Application Ref:	3/2025/0146	 Ribble Valley Borough Council www.ribblevalley.gov.uk
Date Inspected:	17/07/25	
Officer:	KH	
DELEGATED ITEM FILE REPORT:		Decision Refusal

Development Description:	Proposed change of use of land to residential with access track (60m long), gate (2m high) and boundary treatments (1.2m high fences and 1m high stone wall), bin store and parking area to the rear.
Site Address/Location:	Evesons Barn, Simonstone Lane, Simonstone BB12 7NU

Map 1: UKHabs Habitat Survey: Evesons Barn, Simonstone Lane, Simonstone
Survey Date: 02/04/25

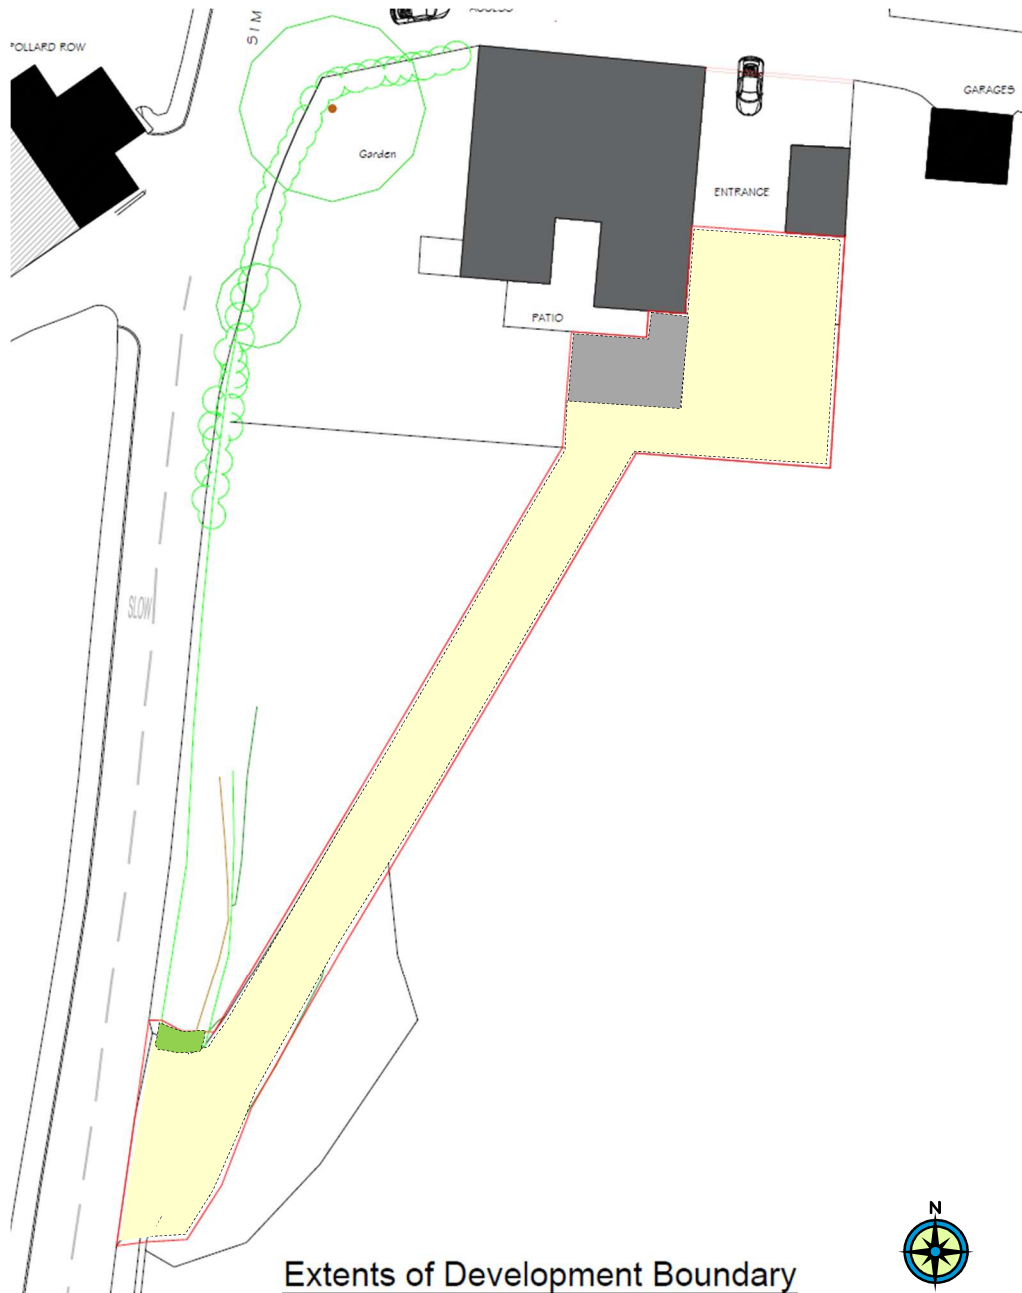
Details of Biodiversity Net Gain have been submitted with the application. The draft BNG report concludes that the proposed works would result in a loss of 0.11 habitat units and 0.01 hedgerow units resulting in an overall loss of 90.45% and 40.59% respectively.

An additional 0.12 habitat units and 0.01 hedgerow units are required in order to achieve a 10% net gain.

Whilst some limited replacement hedgerow of 3m has been shown on the submitted plans no details of improved amenity grassland have been provided, and the application lacks detail on a strategy for how the 10% uplift will be achieved. Additionally, any BNG provision would appear to be reliant on land outside of the red edge, in which case a legal agreement would be required to secure the BNG off-site, however this has not been submitted.

Sheet Title
Existing General Arrangement & Visibility Splays

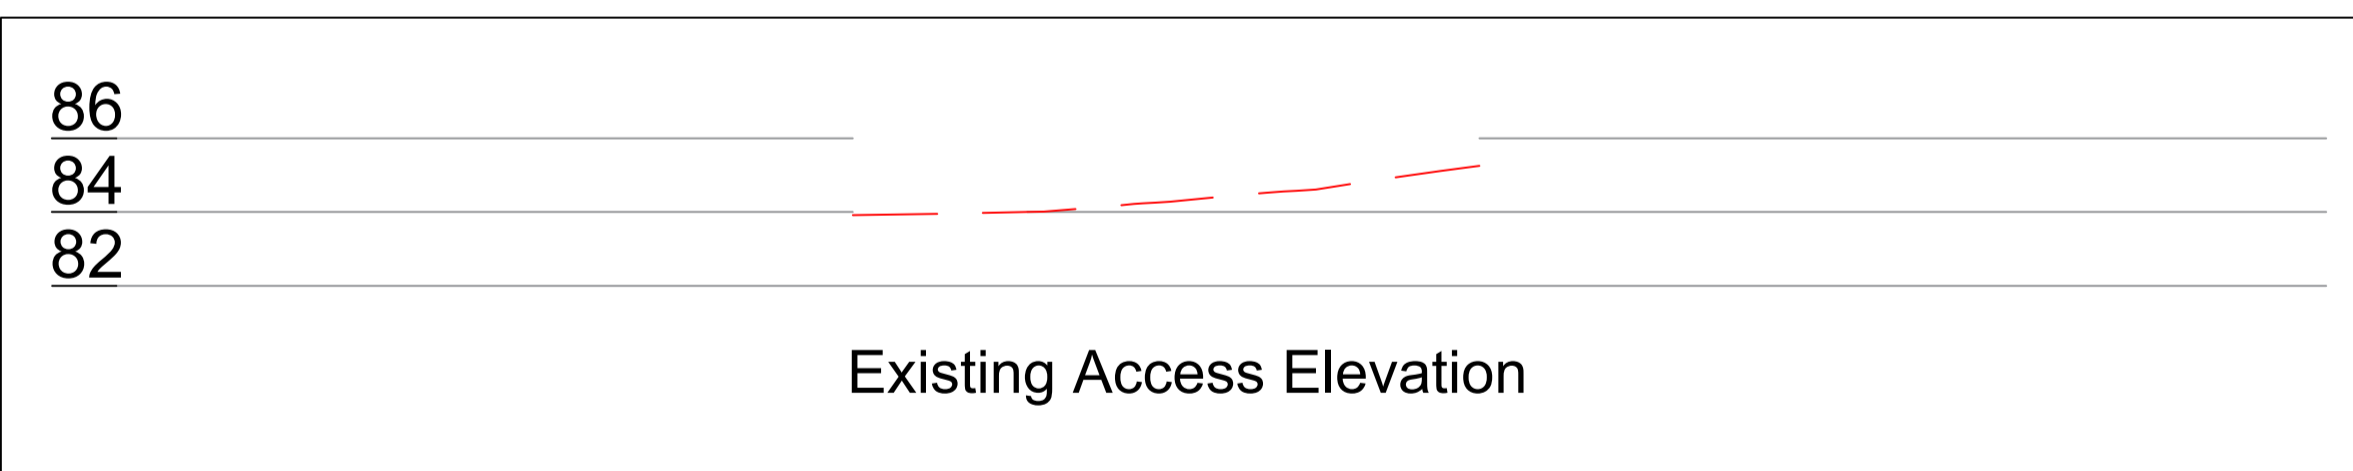
The development could satisfy Paragraph 154(h) subject to the development preserving the openness of the Green Belt. The tarmac access track would extend for 60m in length with a minimum width of 5m running at an angle through the centre of the field separating this into two sections with boundary fencing to both sides and a 2m high, 4.4m wide timber boarded gate within a powder coated black metal frame and stone boundary piers at the entrance. The boundary fences would be formed from 1.817m wide 5 bar timber horizontal rails with 1.175m high timber posts.

The type, length and position of this access road and associated gate and boundary treatments is considered to be out of character and introduce an overtly domestic appearance to the site which is currently an open field that is devoid of any other built form. Therefore, this would be a prominent development that would result in a loss of openness in the Green Belt given that it would introduce built form to undeveloped and open land.

The tarmac track at 60m long together with stone walls, timber gate and fencing would be out of character and domesticated in nature resulting in an overly prominent on this exposed field. There is also a concern that this could lead to more domestication of this land with the track running along the centre of the site thus resulting in a unacceptable impact on the character of the area and the Green Belt in terms of its openness.

The location of the track within the middle of the site linking to the highway at 60m in length is not appropriate and there is no established need for the proposed track to enable access to the site as there is an existing access from the same highway much closer to the barn conversion which is utilise by other adjacent residential properties.

LCC require conditions relating to access materials and drainage, visibility splays and for the existing access to the permanently closed. However, this would not be appropriate as the existing access serves a number of other properties.
